Tel: 01903 737756
Email: planning@arun.gov.uk
www.arun.gov.uk/planning
Please ask for: Amy Anderson
Email: amy.anderson@terraquest.co.uk
Telephone: 0121 234 1390
Our Ref: M/87/25/HH
Your Ref:
Date: 28th October 2025

Application for Planning Permission for Works or Extension to a Dwelling

Development: Single storey side/rear extension and alterations to fenestration, following demolition of existing garage.
Location: 2 Shrubbs Drive Middleton-On-Sea PO22 7SQ

SIDE (NORTH) ELEVATION

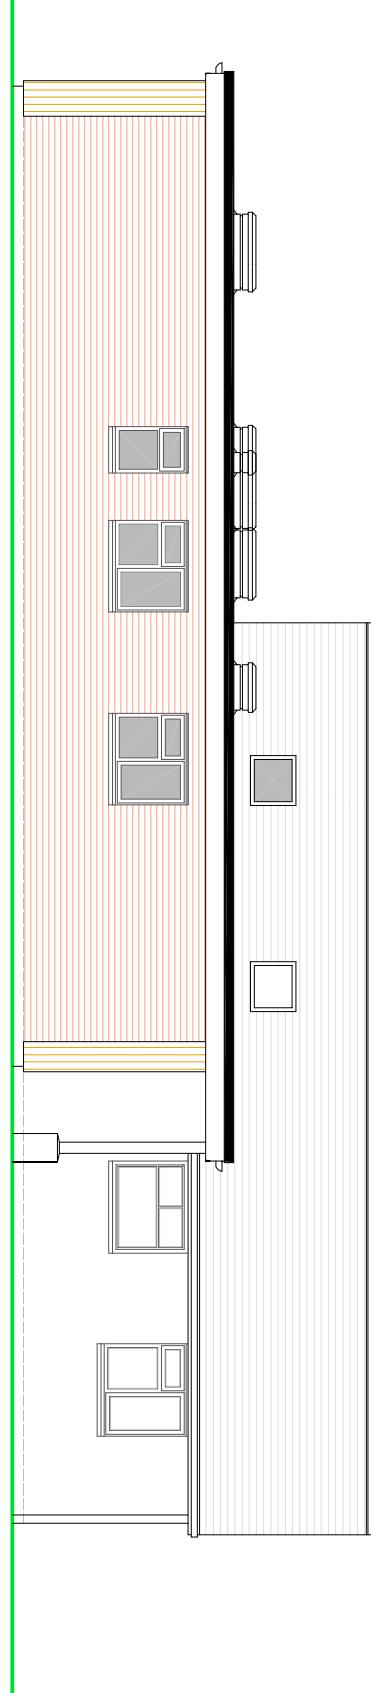
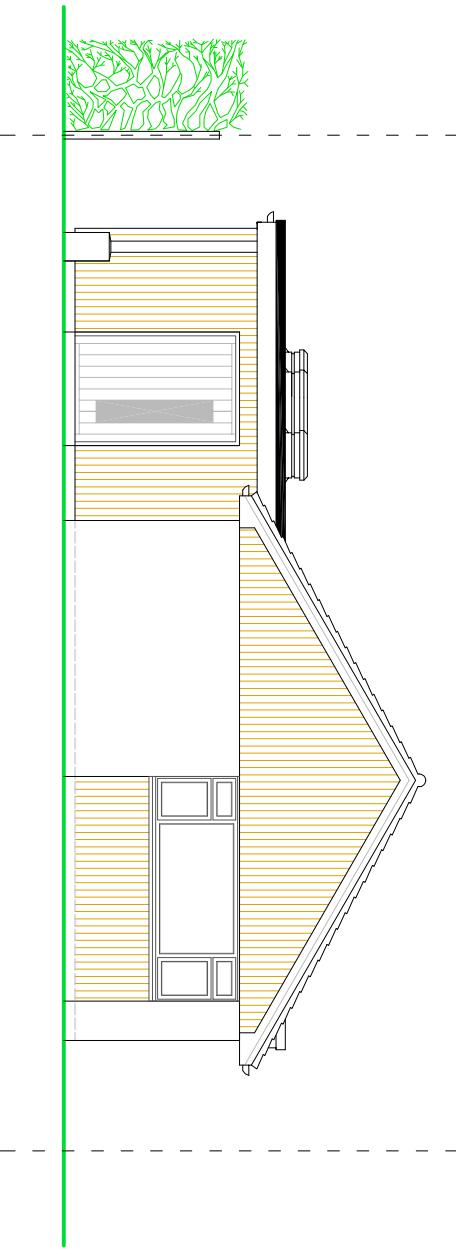
The north elevation shows only 2 windows while the proposed floor plan shows 3. Please review and amend accordingly.
